Retention of playhouse climbing frame in rear garden.
41 Fitzalan Road Arundel

Thank you for your internet representation made on 25th April 2018 which has been recorded as '**an objection**' with the comments as follows:

PROPOSED ROOF PLAN, LOCATION & BLOCK

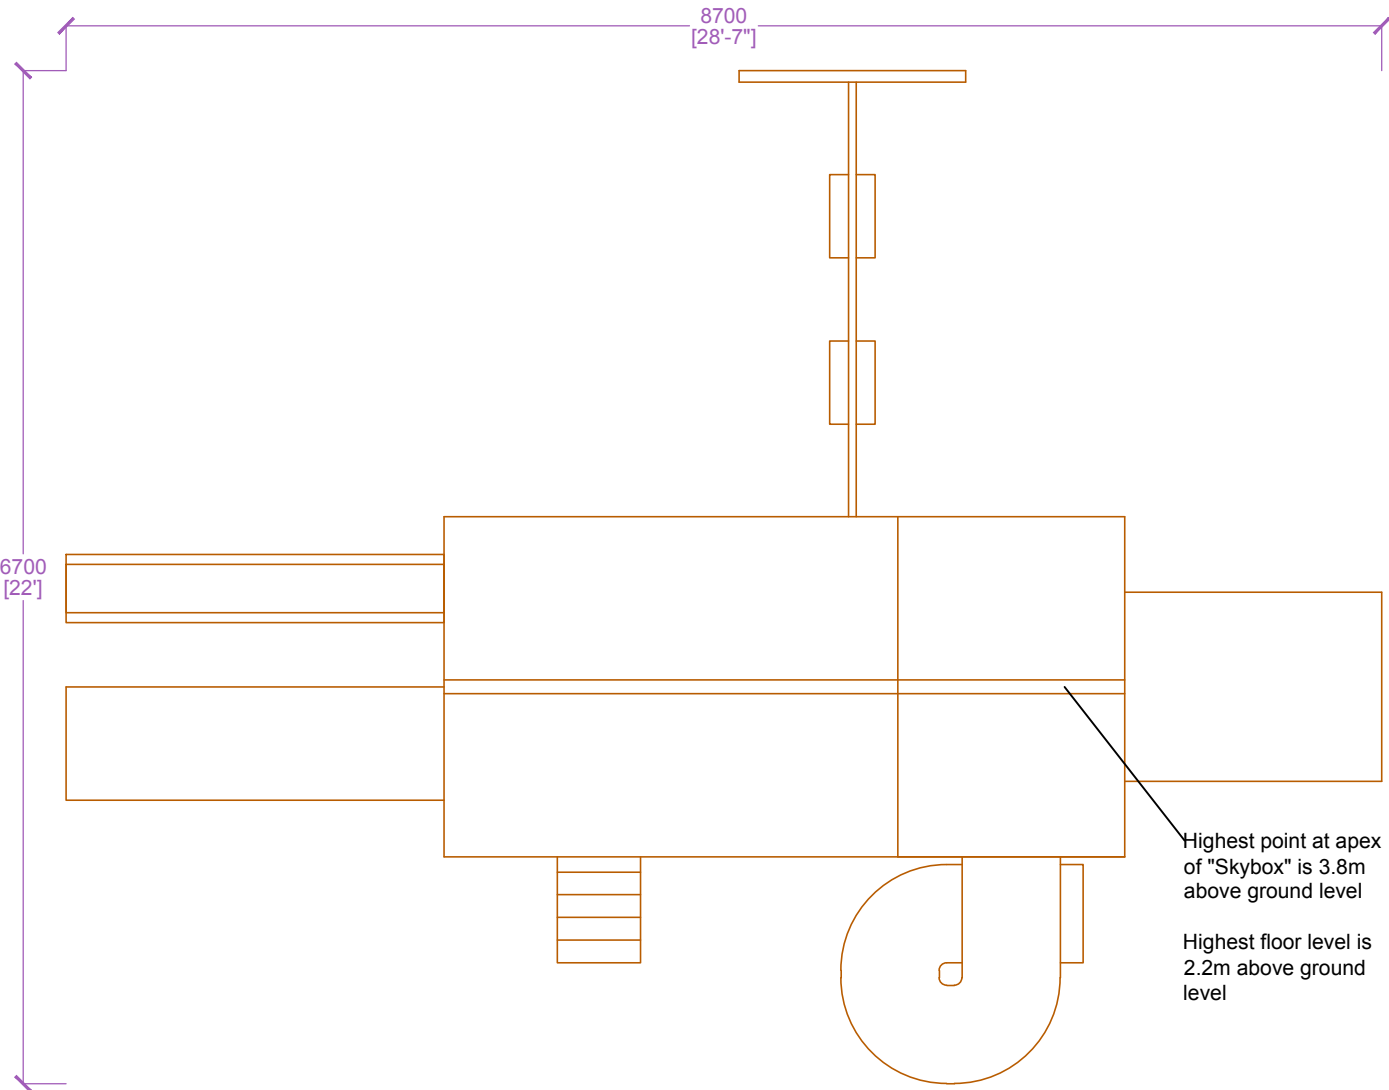
The raised platform of the play frame invades the privacy of neighbouring properties.
